Our ref: XA/2025/100338/07-L01  
Your ref: EN010157  
Date: 19 December 2025

**ENVIRONMENT AGENCY DEADLINE 6 CLOSING STATEMENT. PEARTREE HILL SOLAR FARM, EAST YORKSHIRE.**

This document sets out the final position of the Environment Agency (EA) at the close of examination for the application for a Development Consent Order for Peartree Hill Solar Farm.

- PROPOSED GRAVEL BASE STORAGE AREAS
- PROPOSED PIPES
- INSPECTION CHAMBERS
- HYDROBRAKE OR SIMILAR APPROVED
- PROPOSED OUTFALL TO DITCH

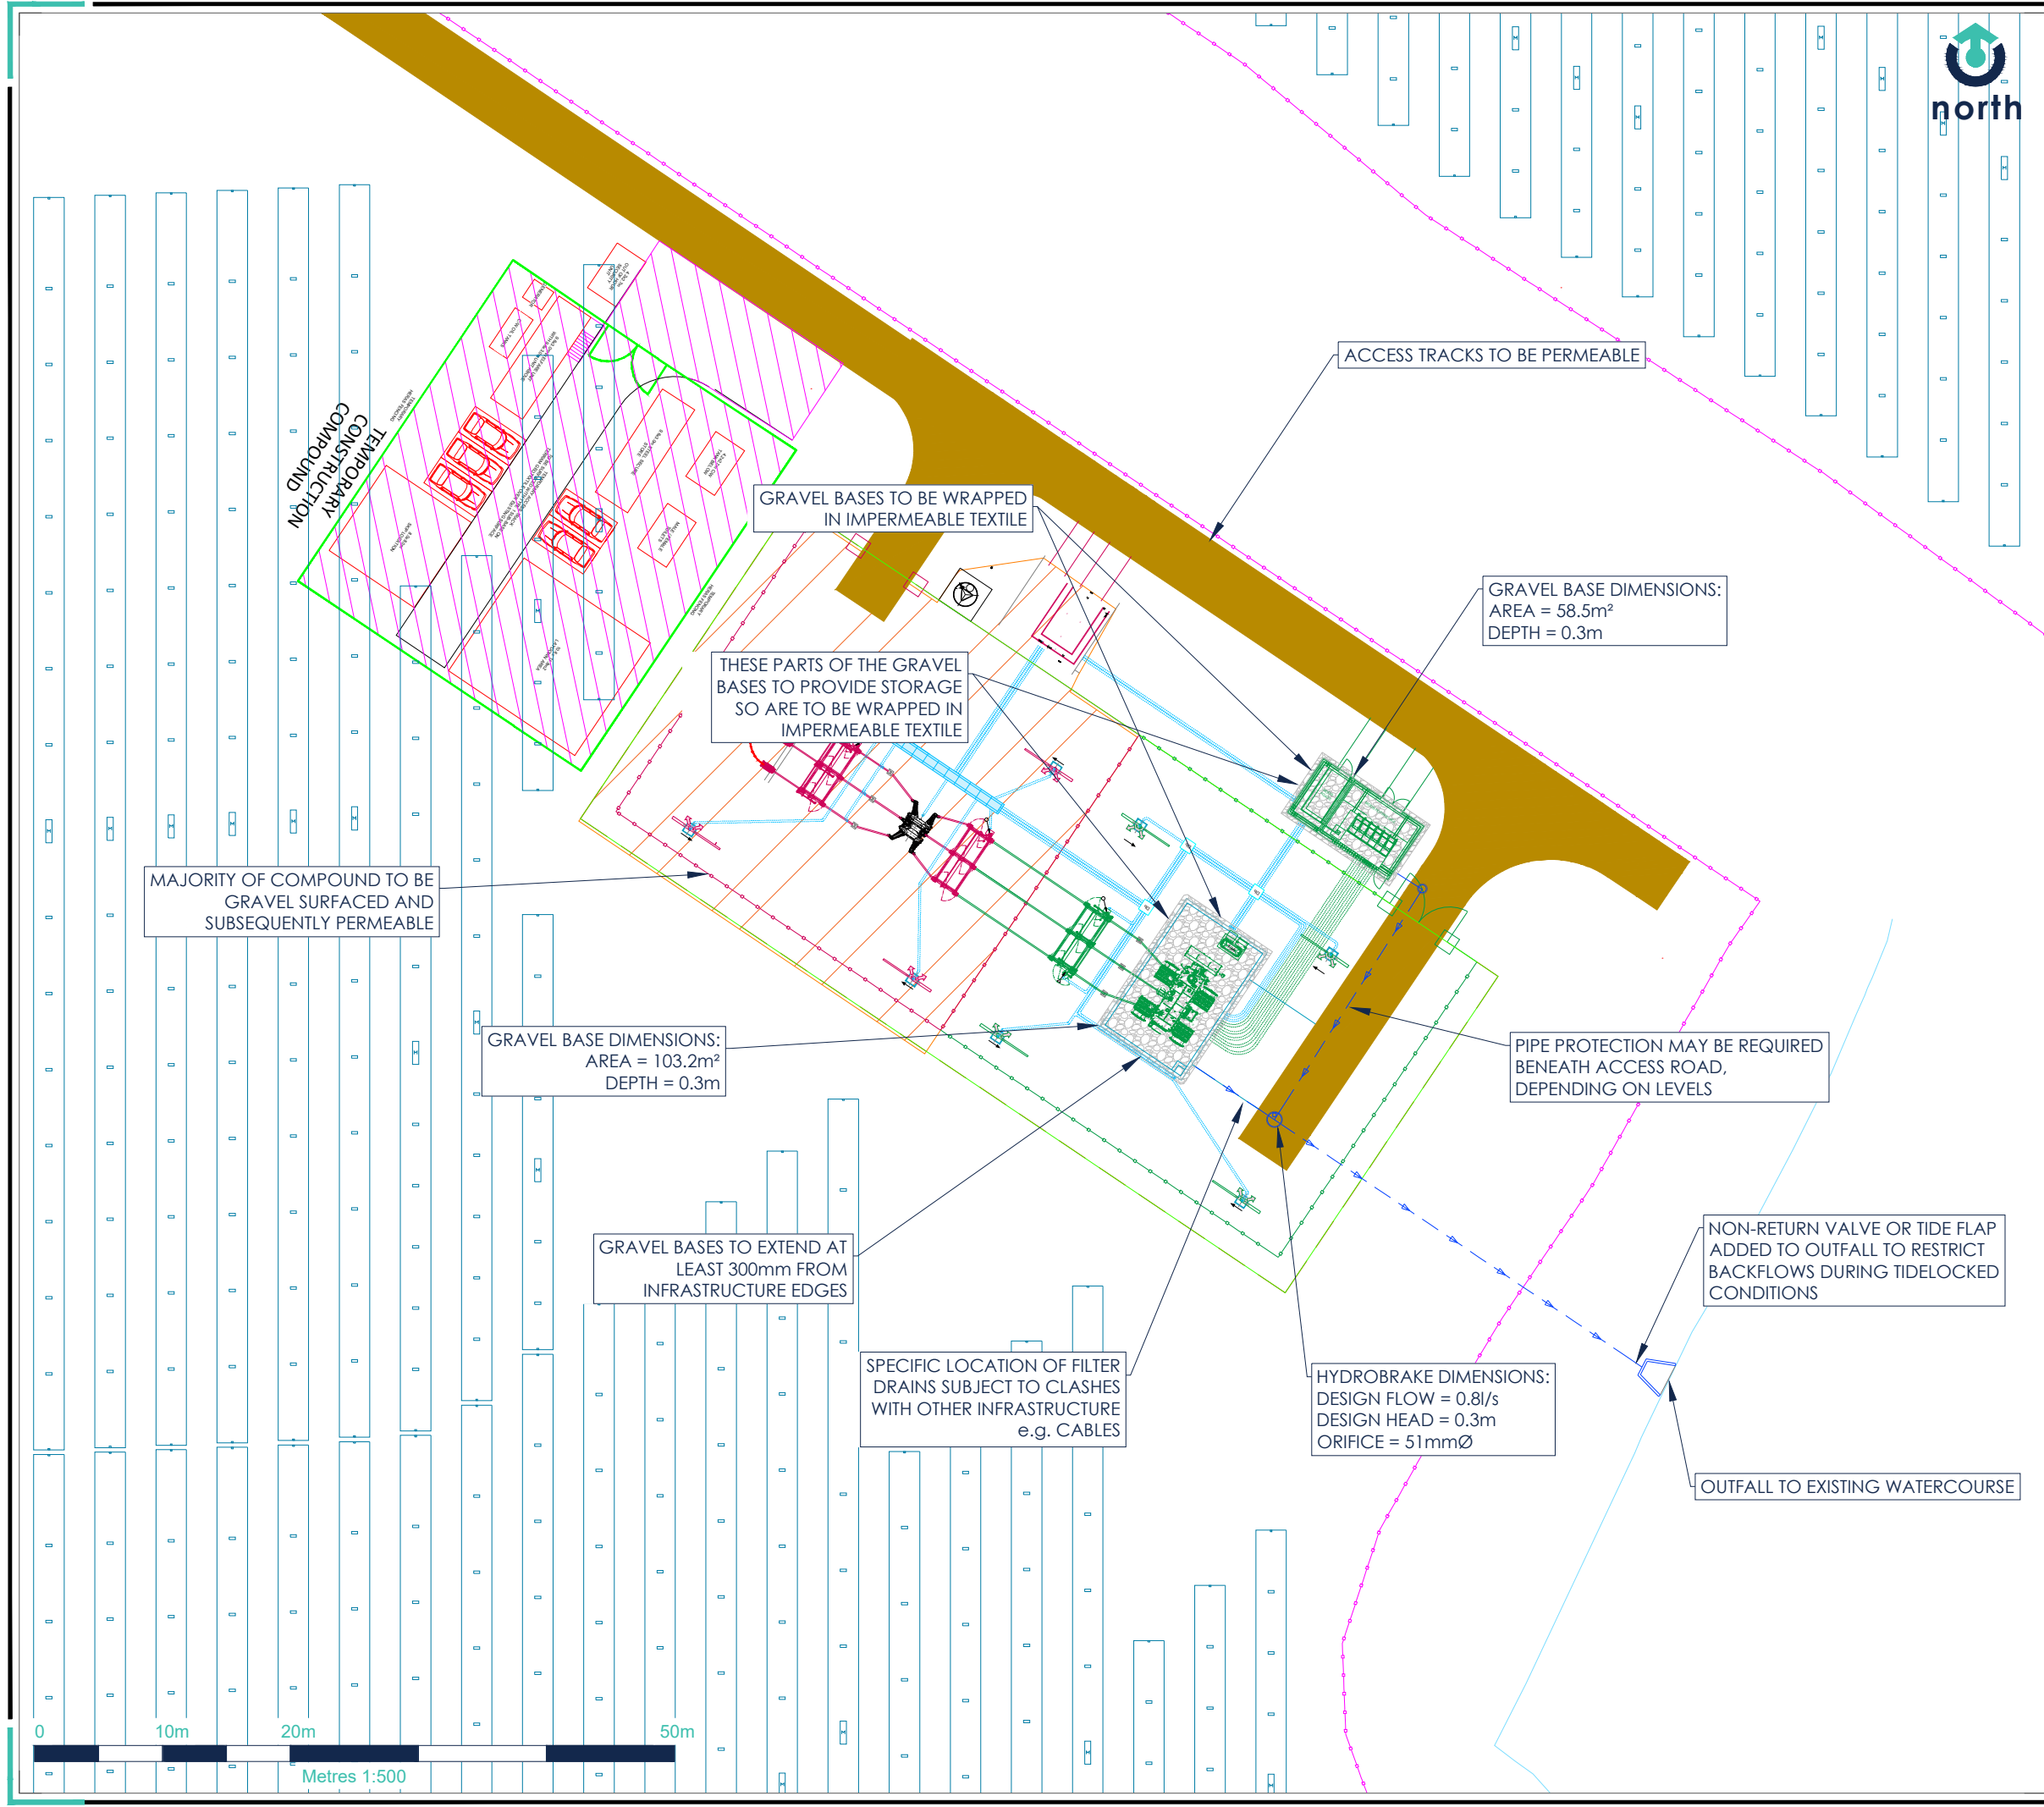
Our significant concern is with the use of "a permeable geotextile to encourage percolation to the ground", as described in the WFD Screening and Scoping Report [[REP5A-007](#)]. This poses a risk to groundwater, as the Applicant has not sufficiently explained how their measures or the underlying geology will restrict the flow of contaminants to the groundwater in the Principal aquifer and SPZ3 that underlie most the site. Additionally, there is a risk to surface waters, as acknowledged by the Applicant in section 3.4.27 of the same report: "the pathway for contaminants released during a fire to enter the surface water bodies is limited but possible". This means that there remains a risk of pollution.

- Clarification about the operation and maintenance of the penstock valves that are proposed for some of the hybrid compounds, as detailed in sections 3.5.50 & 3.5.51 of the WFD Screening and Scoping Report [[REP5A-007](#)].

- Additional figures showing the final drainage scheme, to provide clarity of the locations that will discharge to groundwater, and surface waters. A diagram, including cross-sections for all different types of drainage solutions across the scheme (e.g. positively drained with penstock, gravel and sand drainage), should also be provided.

**(3) Any BSMP submitted for approval under sub-paragraph (1) must include the final drainage solution to show all discharging locations for groundwater and surface waters, and include details on the testing of firewater, gravel and sand for contaminants, in the event of a fire. Should contaminants be present, any contaminated material must be removed to reduce the risk of secondary contamination to controlled waters and remediation of soils, groundwater and surface water should be undertaken if risk assessments deem it necessary.**
